Reference: MP 10_0057 MOD 3 /
4 October 2011

Council comments in response to *notification of modification request to amend Condition B1A(f) and B12(a) at 132-138 Killeaton Street, St Ives (MP 10_0057 MOD 3)*

CARPARK LEVEL 2 STAGE-2
SCALE 1:200

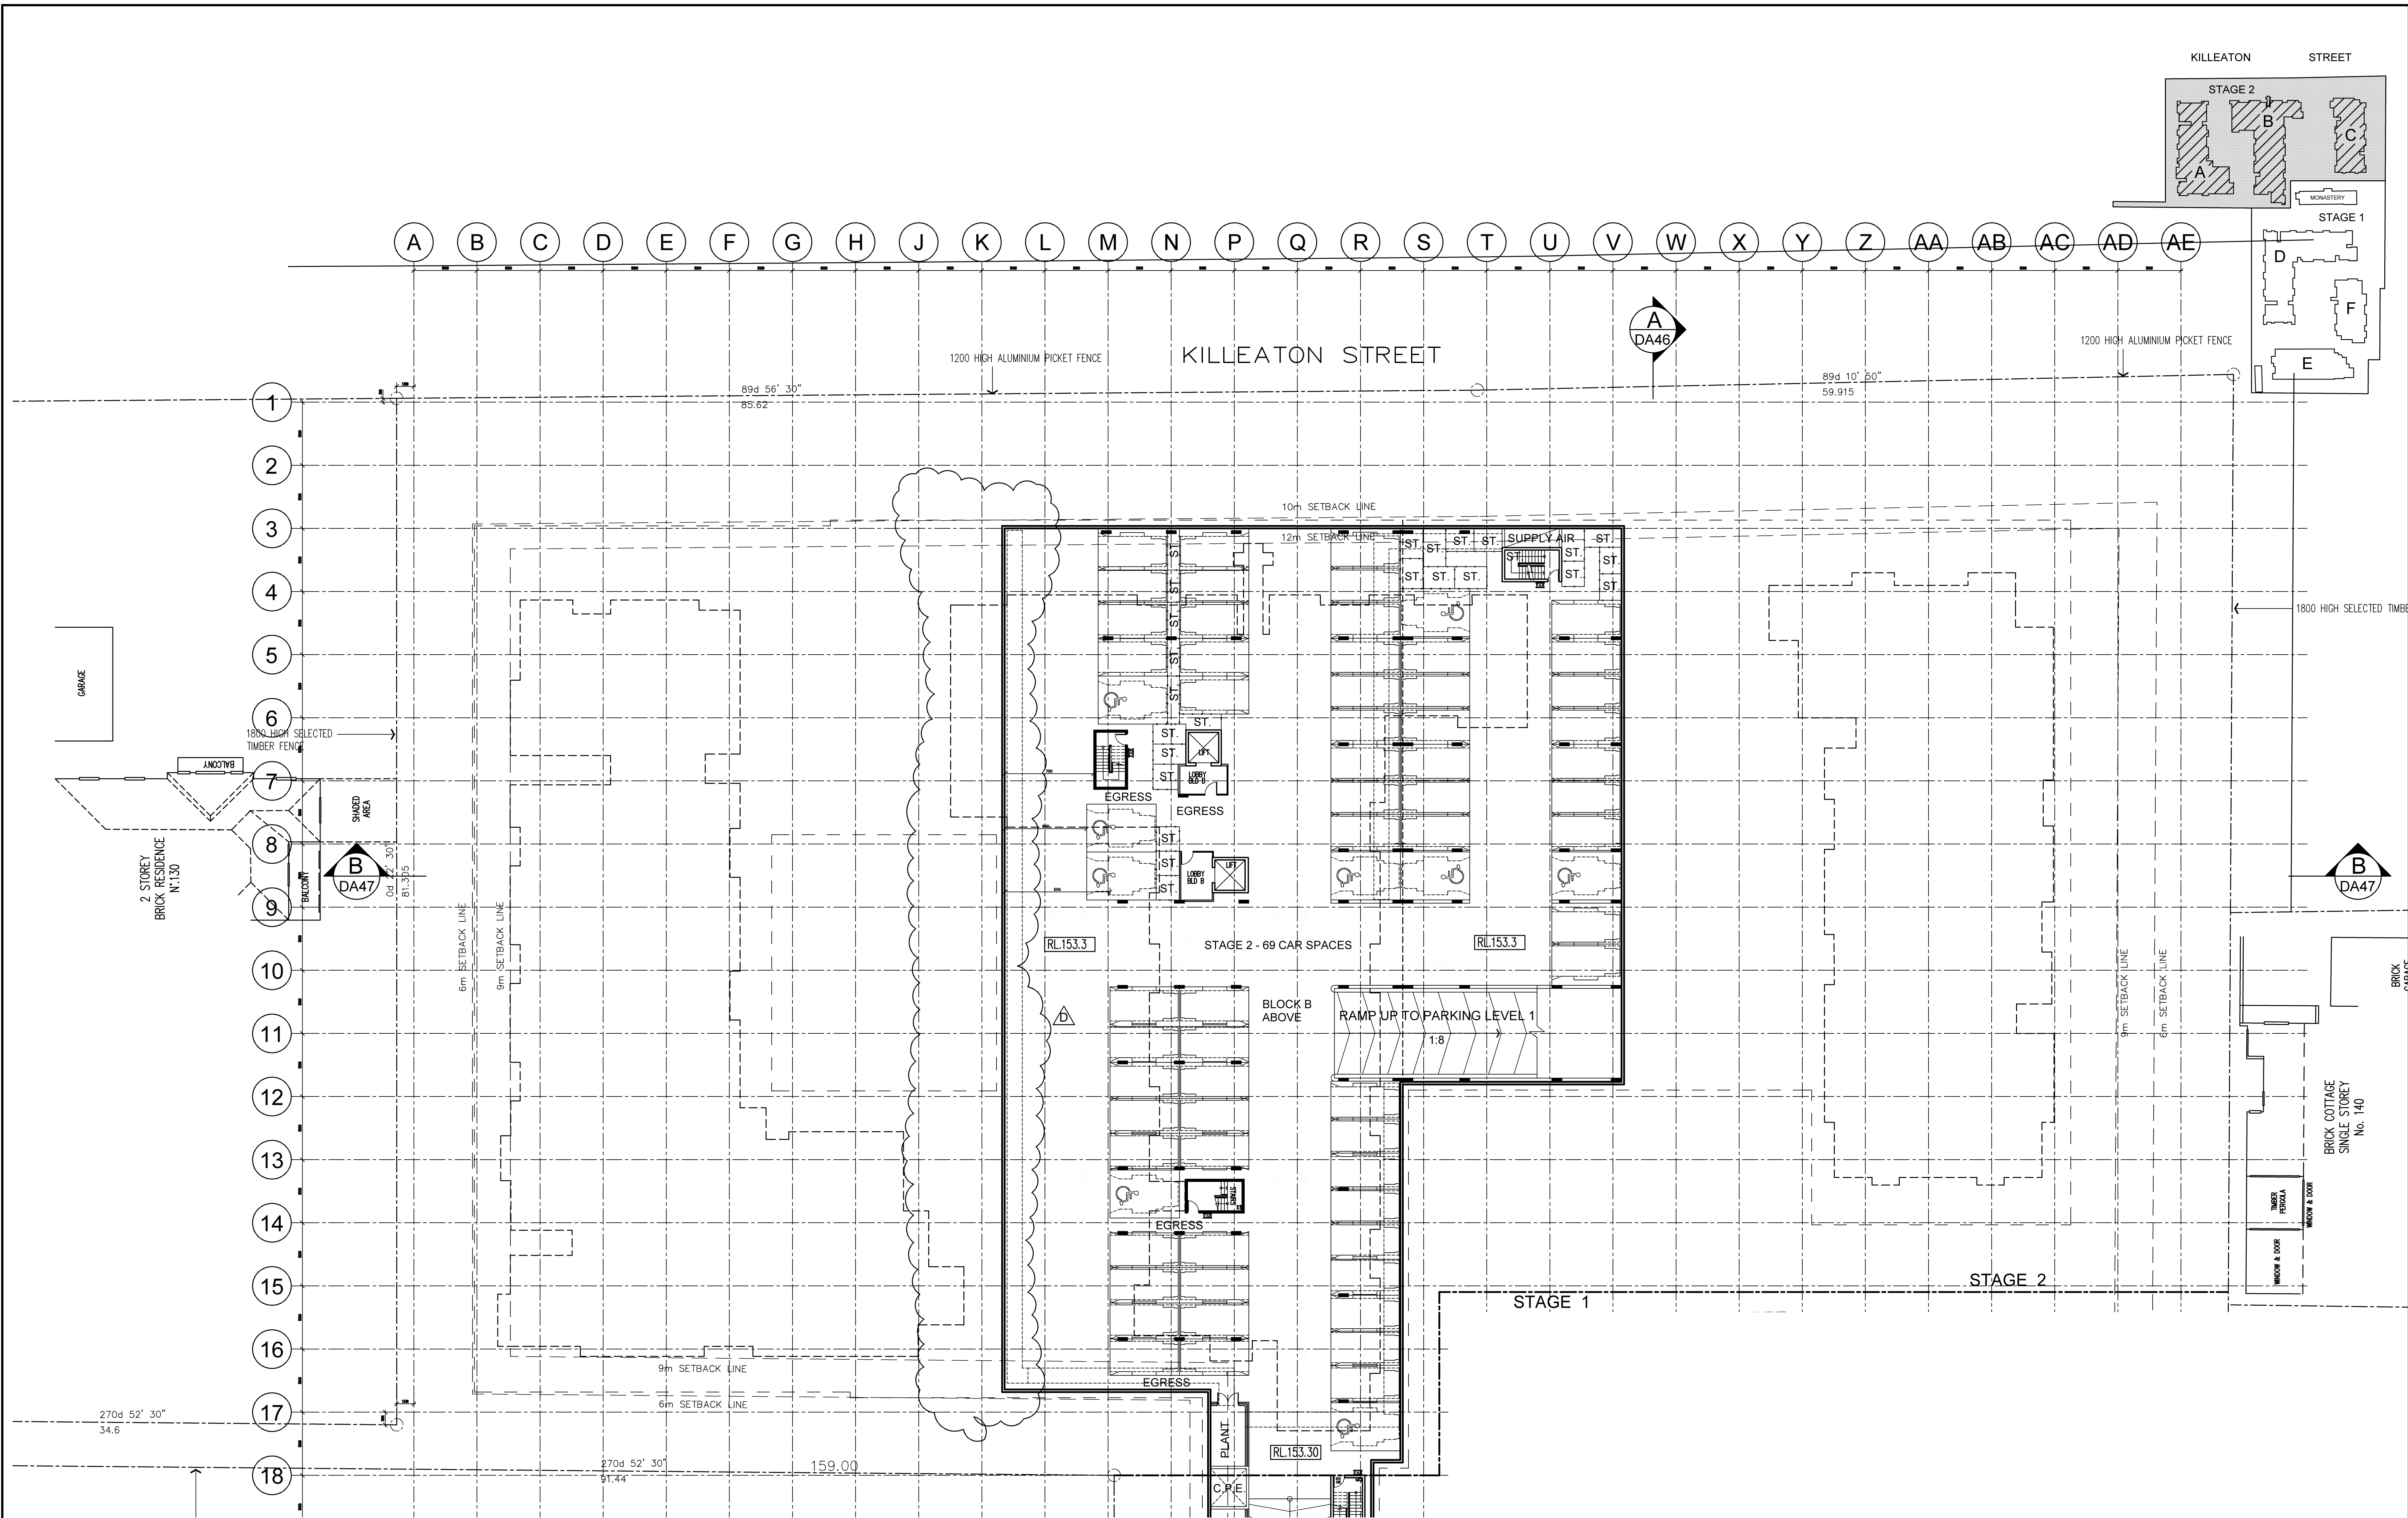
The proposed amendment will reduce the visitor parking provision from 75 spaces to 48 spaces, with existing resident parking spaces to remain the same.

The visitor parking provision of 75 spaces was made in accordance with Council's DCP (Town Centres) 2010, as well as Council's DCP43 (Car Parking), which required visitor parking at the rate of 1 space per 4 dwellings. The proposed amended visitor parking provision of 48 spaces equates to a visitor parking provision at the rate of 1 space per 6.2 dwellings (approx), which is lower than both Council's DCP (Town Centres) 2010 and Council's DCP43.

While a reduction may be appropriate in a Ku-ring-gai town centre that is supported by a combination of rail station, bus services and local employment/core retail and commercial services; it is considered that visitor parking rates in St Ives should be retained at a ratio of 1 space per 4 dwellings. This is based upon the above, but of equal importance, while St Ives has a number of relatively good frequency bus services, it does not have a rail station nor significant local employment (apart from retail activities in the town centre itself). Further, the site is some 600m in a straight line (or 700m walking distance) from the retail core (intersection Mona Vale Rd and Memorial Ave), and as such the site is unlikely to benefit from multi-purpose trips from visitors to the town centre which may also be visitors to the apartments. Failing to provide adequate visitor parking may result in impacts on-street and to surrounding residents.
